24-C-1
211 Marginal Way
Bayside East
Tranum & Co.

Project Name/Description

Re: Bayside East, 211 Marginal Way, Portland, Maine (formerly Strictly Formal)

From: Rick Knowland
To: Internet:stst@tffharchitects.com
Date: 3/20/03 1:44PM
Subject: Marginal Way project

**LANDSCAPING PLAN**

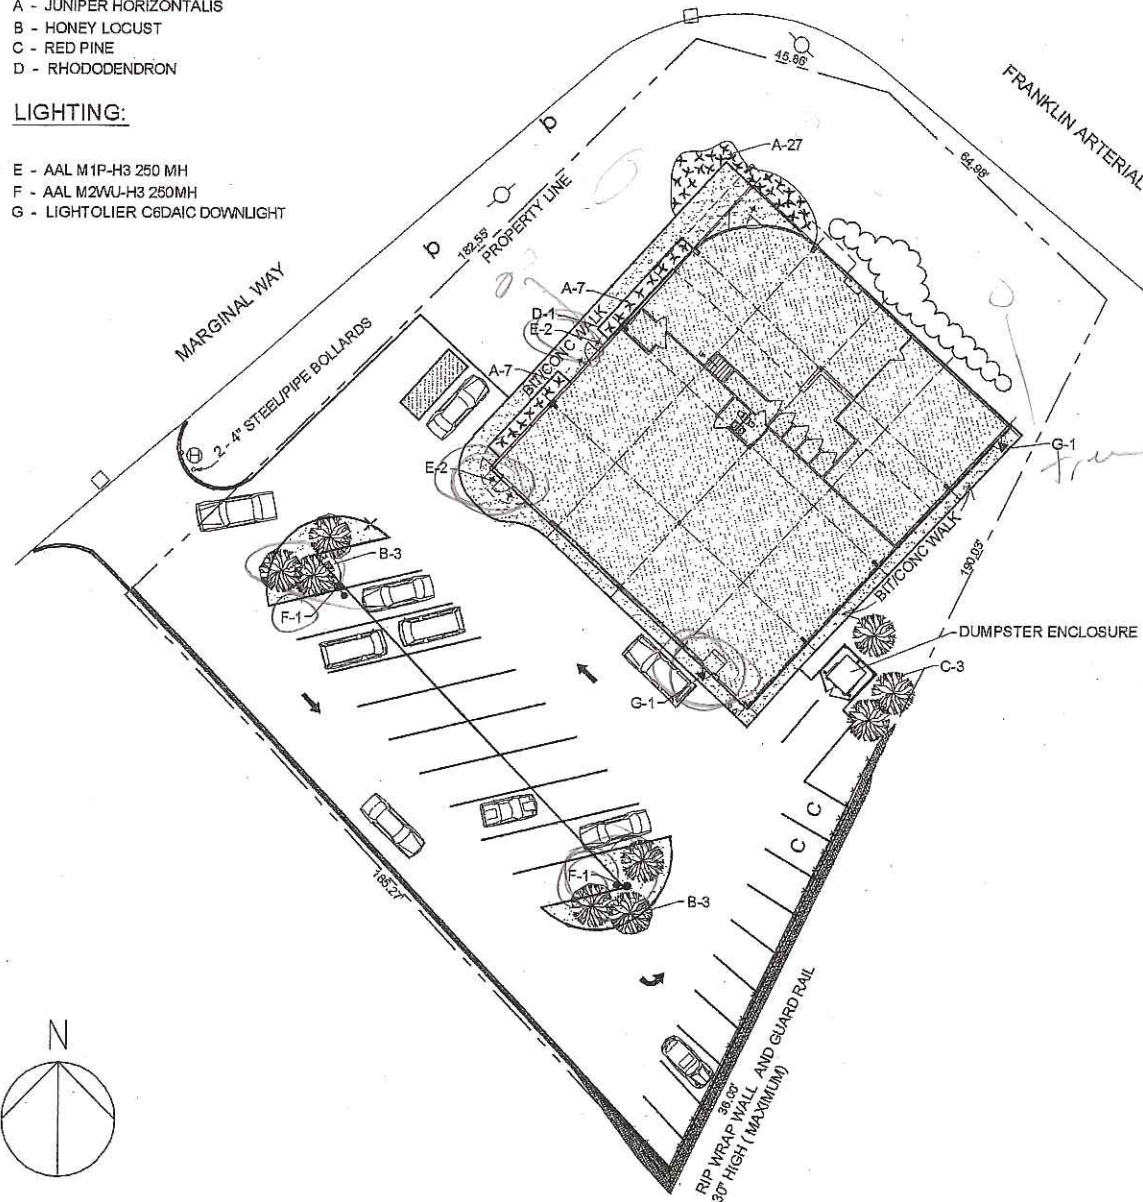
9. Landscaping. Jeff Tarling, City Arborist, is in the process of reviewing the plan. Will forward comments when they are available. Street trees should be planted along Marginal Way and Franklin Street. Obviously a tree cannot be planted on top of the propane tank. The "no curb" around the islands is not going to work. Curb is needed to protect the tree and keep the bark mulch in place. Suggest using a cape cod berm.

6 RIP RAP / GUARD RAIL  
NOT TO SCALE

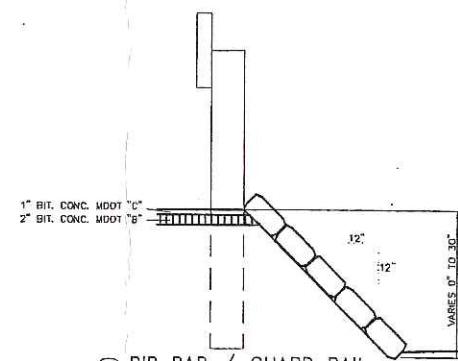
7. The guard rail at the rear of the property. What type of material will it be?

6. Enclosed is a copy of the deed that contains a description of the easement that runs through the property.
7. The guardrail at the rear of the property is pressure treated timber. See Addendum notes that have been added to Detail 5 on sheet Site 2.

**SITE PLAN**  
1" = 20'-0"

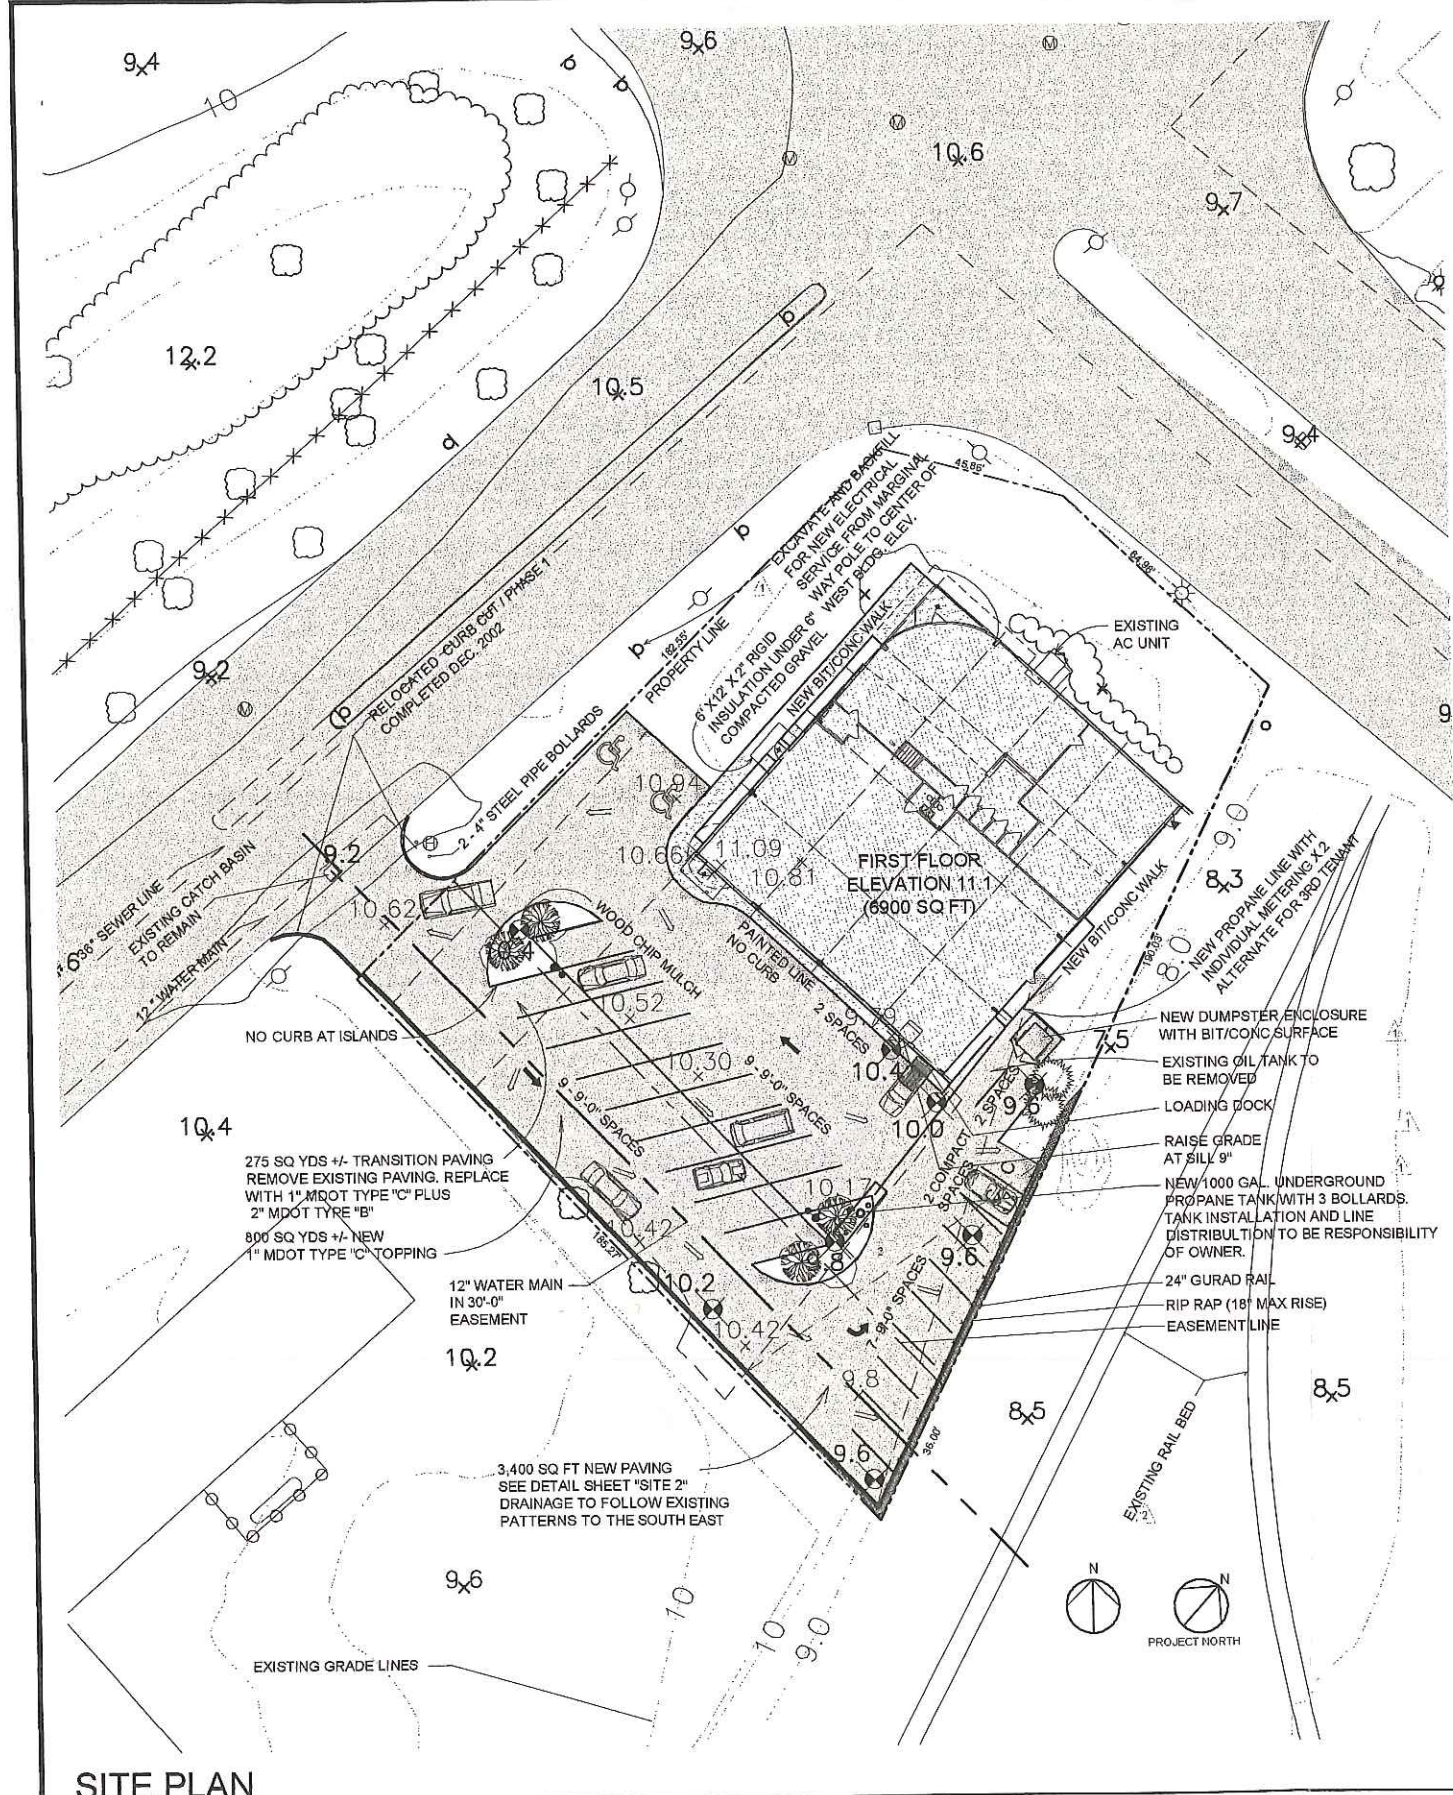
2. A water quality unit needs to be installed on the site for the parking lot. Indicate location, type, relevant specs and capacity.

3. The underground propane tank can't be placed under a parking space per Fire Dept. comments. Show footprint of the tank so we know the same space is not occupied by a parking space. Also you should be aware there are special requirements for the tank in terms of vents and underdrains, etc.

5. Reconfigure the rear parking spaces to a different angle. They won't work at the angle shown on the plan.

8. There should be a curb or guard rail along the westerly property line (AAA repair facility) and along the Marginal Way side of the parking area so that cars stay on the site. We are not enthusiastic about all metal guard rails.

10. Show existing utility lines into the property.

1. See enclosed Site 1 and Site 2 drawings revised 3/31/03 in response to Sebago Technic's letter dated 10-16-02.
2. With regards to surface water: We are not changing the existing drainage patterns. We propose to sheet drain the lot as it presently functions. You will note that approximately 2,500 square feet now flows into the catch basin with the rim @ 9.2 feet. The remainder of the lot will sheet drain to the southwest and southeast. Given that we are maintaining the existing drainage patterns, we do not see the need for a water quality unit.

3. I have reviewed the propane tank installation location and details with several suppliers. We must keep the tank within the island to avoid dropping it 4'-0" below the surface. Paving may not come within 5'-0" of the fill. Bollards are suggested. We have adjusted the drawings accordingly.

4. The square footage of the building is 6,900 square feet. The B-5 zone calls for "one space for every 200 square feet of first floor area in excess of 2,000 square feet not used for bulk storage." This equates to 25 cars. There are presently 22 possible spaces. The revised parking layout dated March 25, 2003 will create 31 spaces. The note on sheet Site 1 "Zoning Requirements" has been revised accordingly.

5. You will note from the revised drawings that we are now proposing 31 spaces (17 - 9'-0" spaces between the proposed plant islands in the center of the lot, 2 - handicapped spaces in the northerly corner, 10 - 9'-0" spaces along the south side in the new paved area and 2 - parallel spaces along side of the building.
